**FINAL DRAINAGE REPORT
FOR
STERLING RANCH RECYCLING FACILITY**

**February 2024
Project No. 25188.14
PCD Filing No: PPR2341 & SF2325**

STERLING RANCH RECYCLING FACILITY PROPOSED DRAINAGE MAP

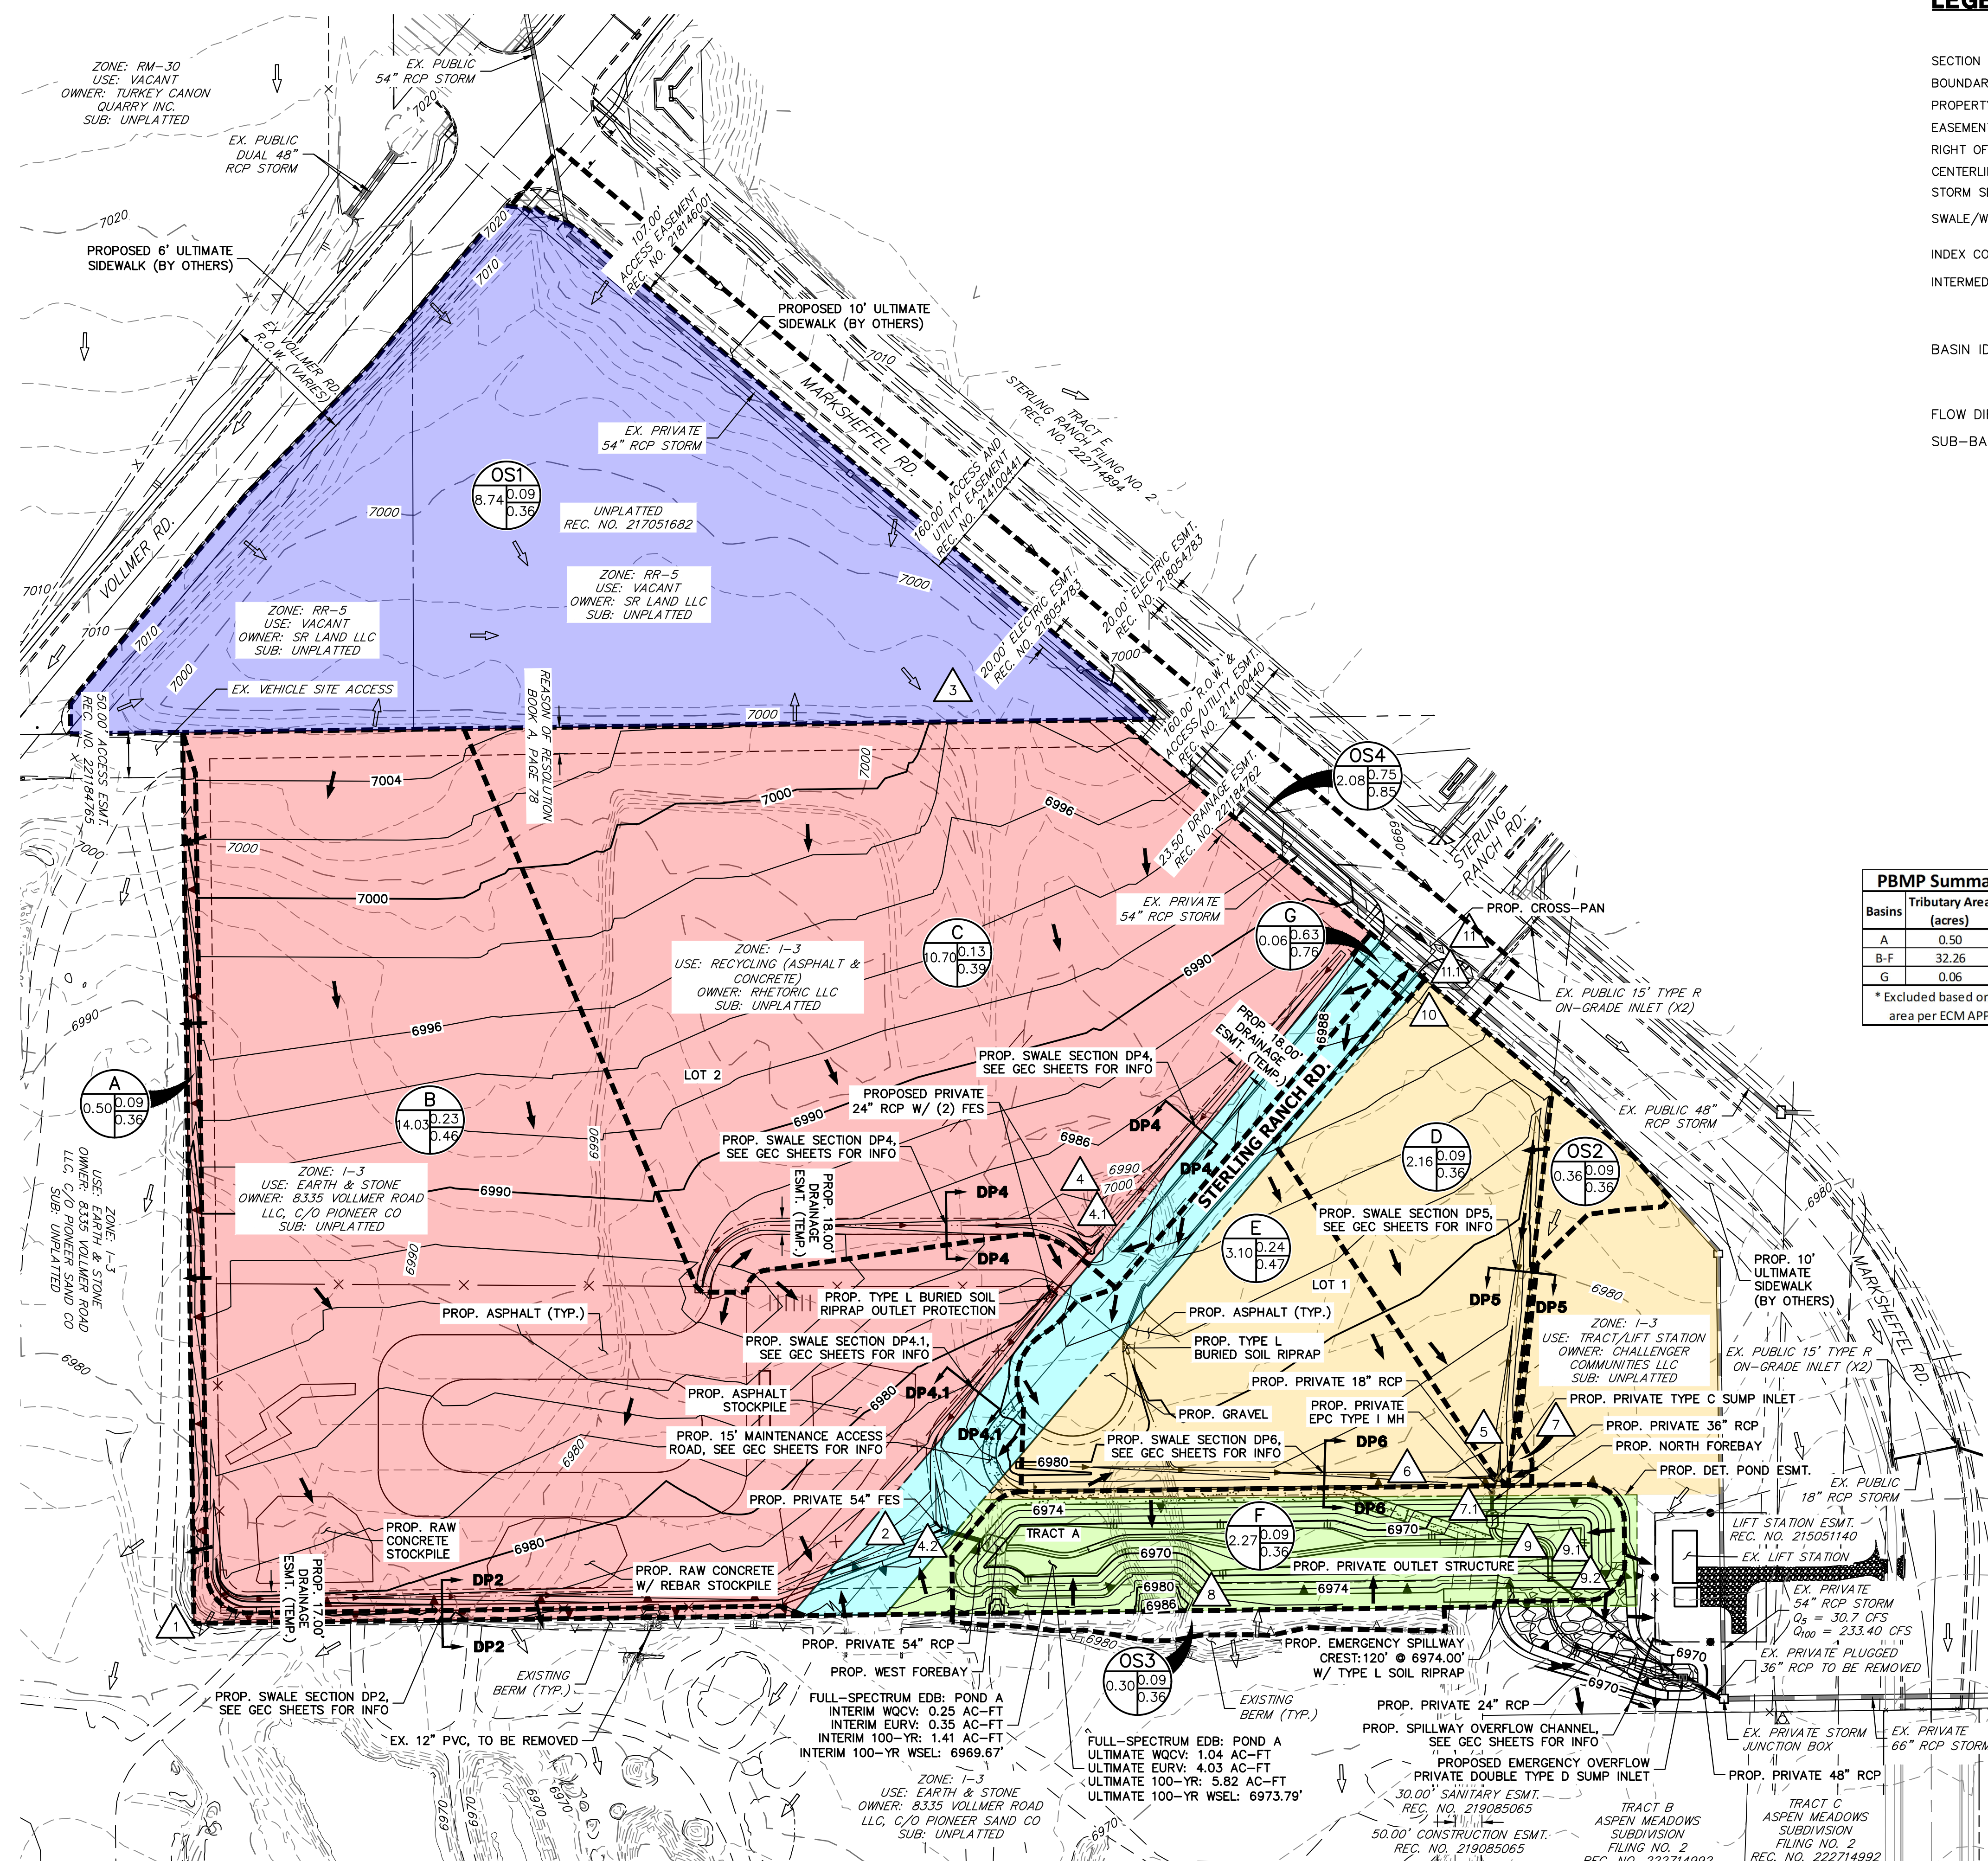
Explain why this basin is considered "off-site" when it is shown within the LOD on the GEC Plans for this project. And address WQ treatment/exclusion for it. Is runoff from it to be treated via a previous or future project for the road?

JR Response: This basin is located not on the property, so it is considered off-site. Added statement about existing report that analyzed this basin and how our development only proposes an access location and shows a decrease in basin flow.
